From: Chris Moore
Sent: 24 June 2020
To: Sian Eggington
Cc: 'Shaun Taylor'
Subject: FW: Request for further information P/55/20/HH
Attachments: We sent you safe versions of your files; P_55_20_HH20200624100991570.pdf; Garage Detail.pdf; Site Plan 500.pdf; Location Plan.pdf

Subject: Request for further information P/55/20/HH

GROUND FLOOR PLAN

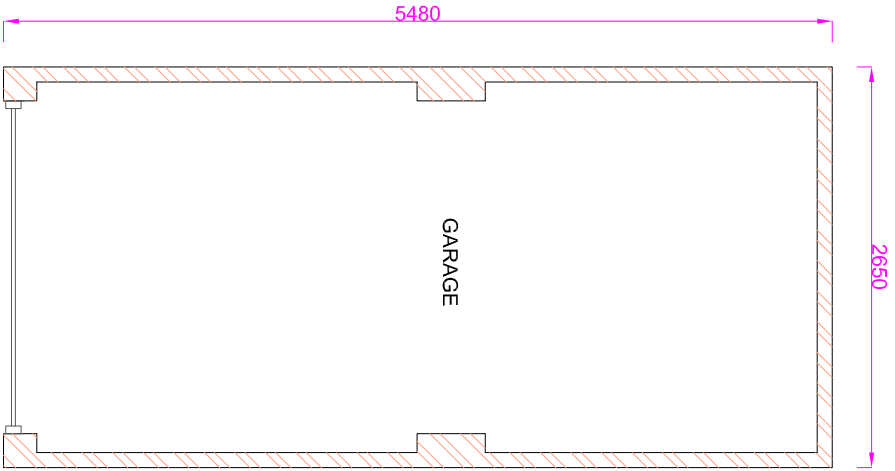
Room Labels: You are required to have room labels on all floor plans. Please amend. – Amended.

Site Plan (scale 1:500)

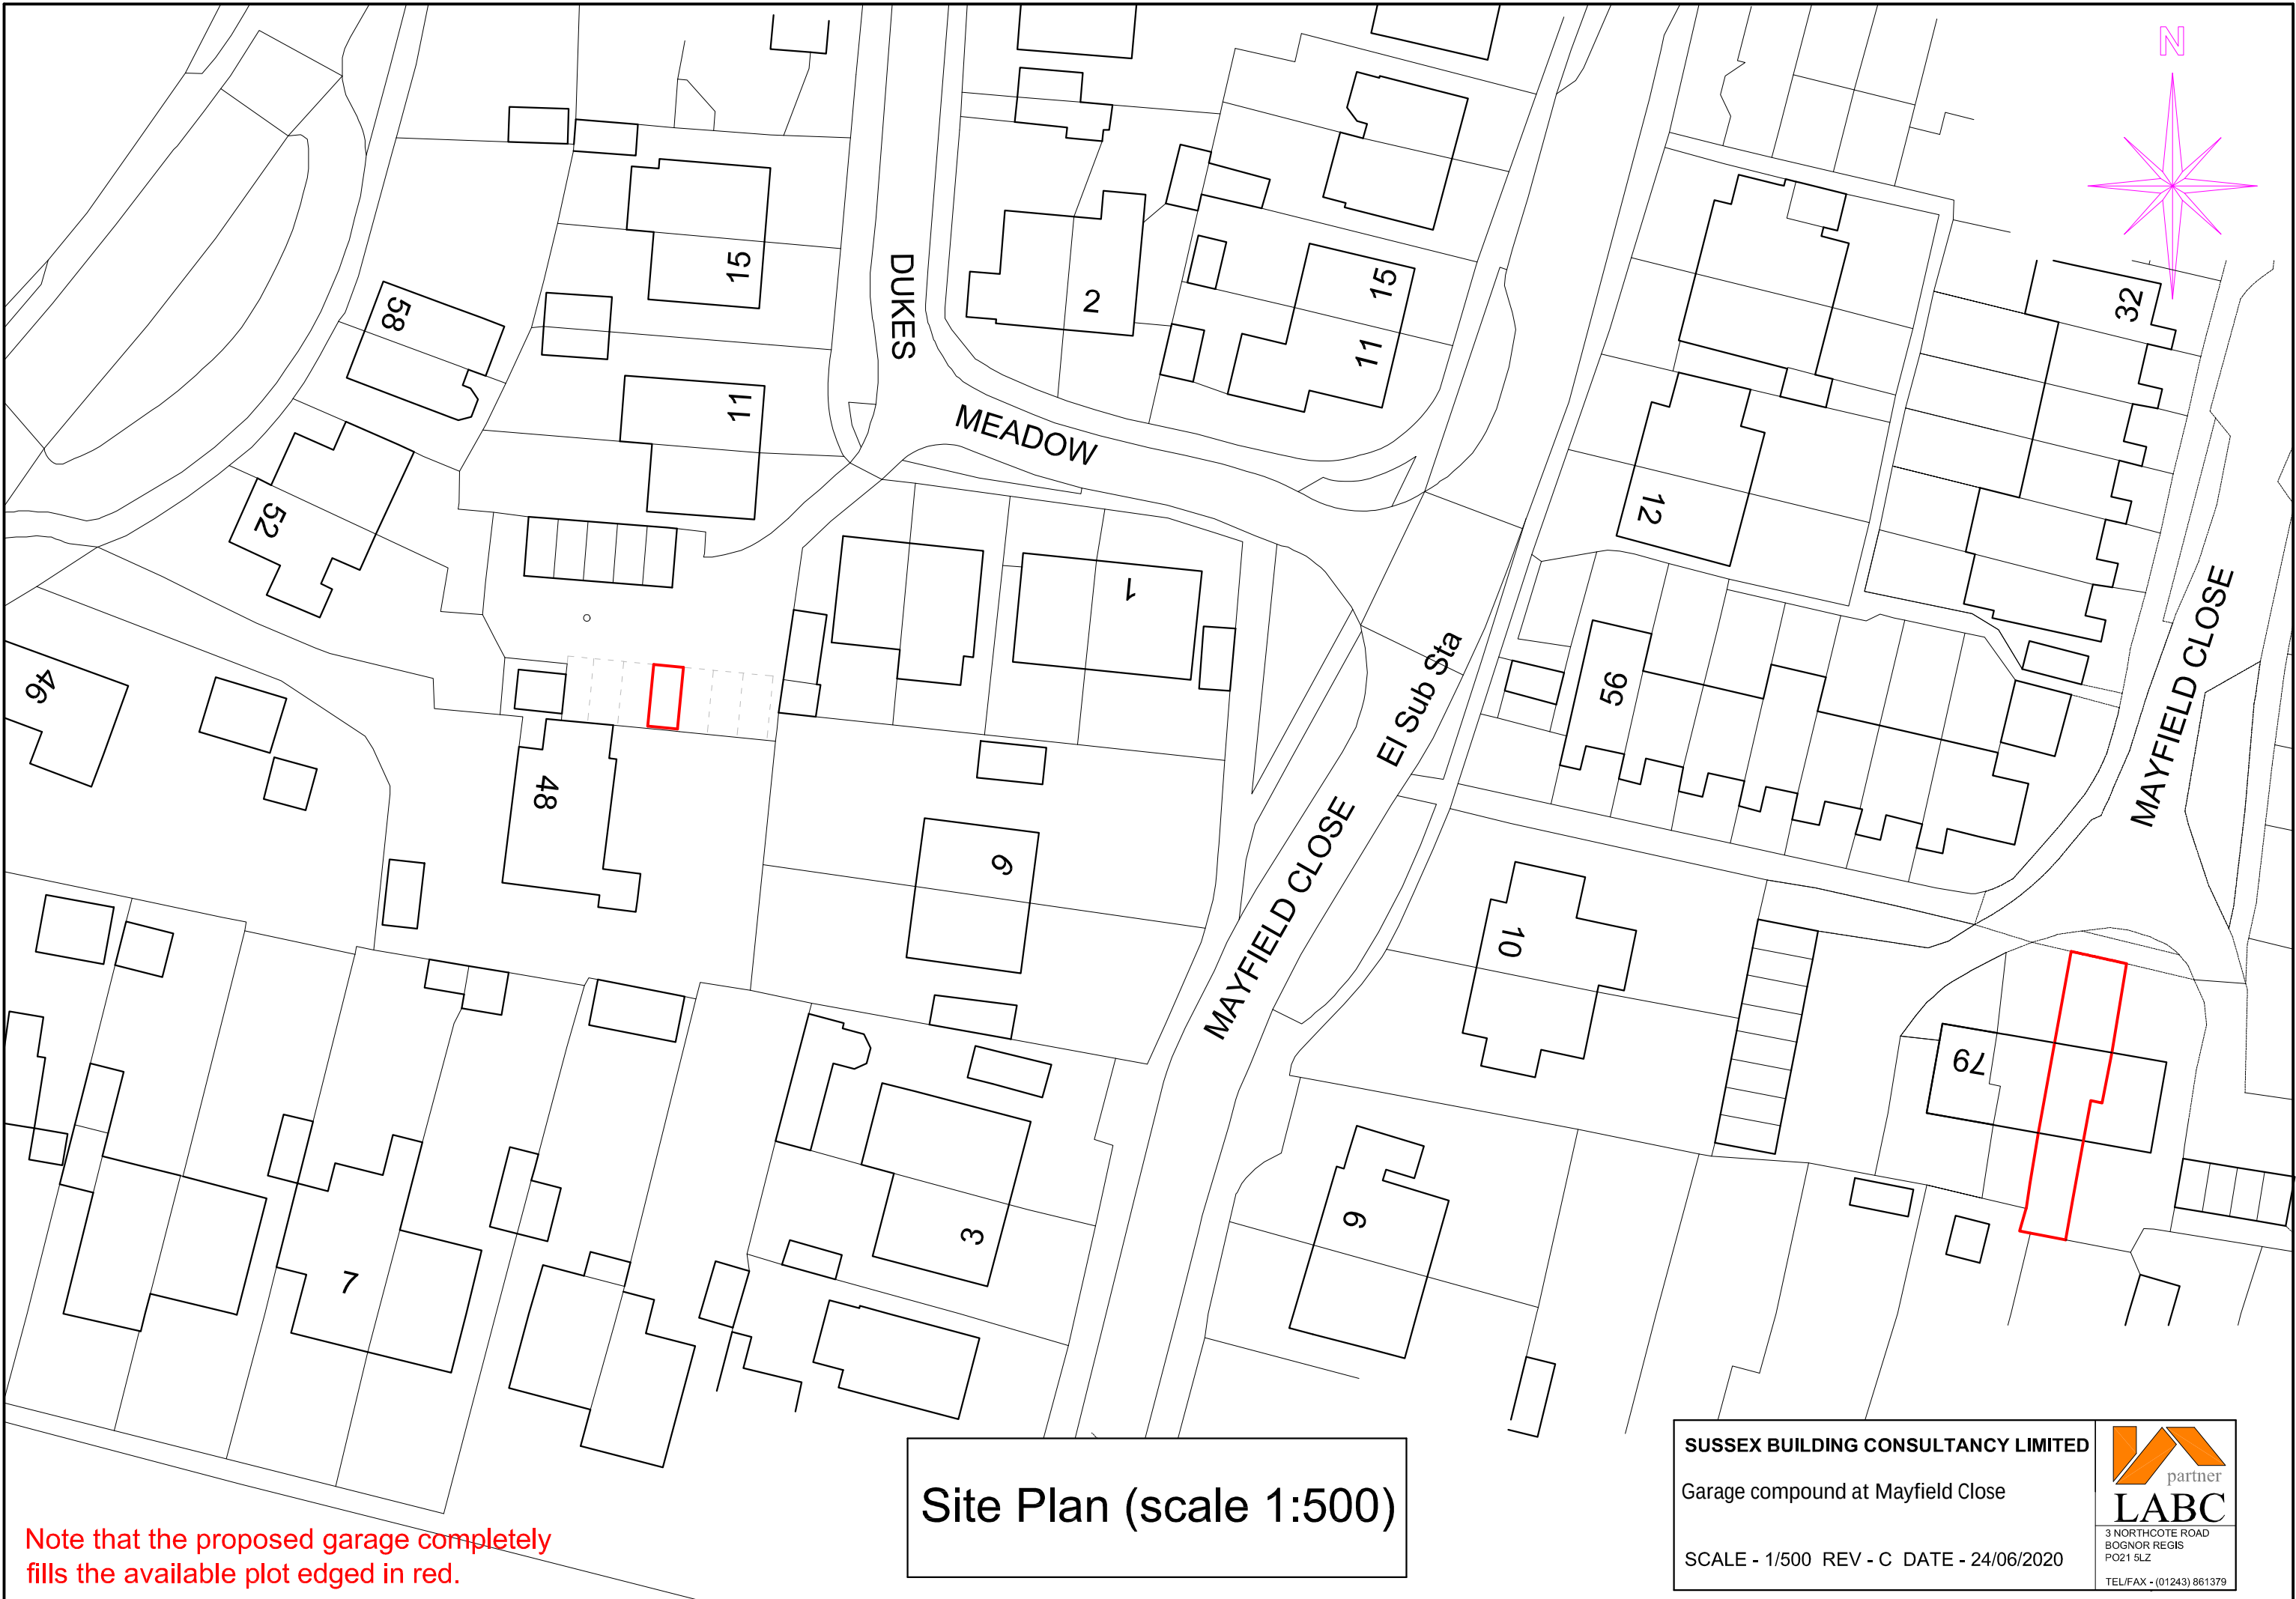
Block Plan: Please submit a proposed block plan with dimensions to all site boundaries. – The new garage completely fills the available plot size so no distance to boundaries – I have put a note in RED on the site plan.
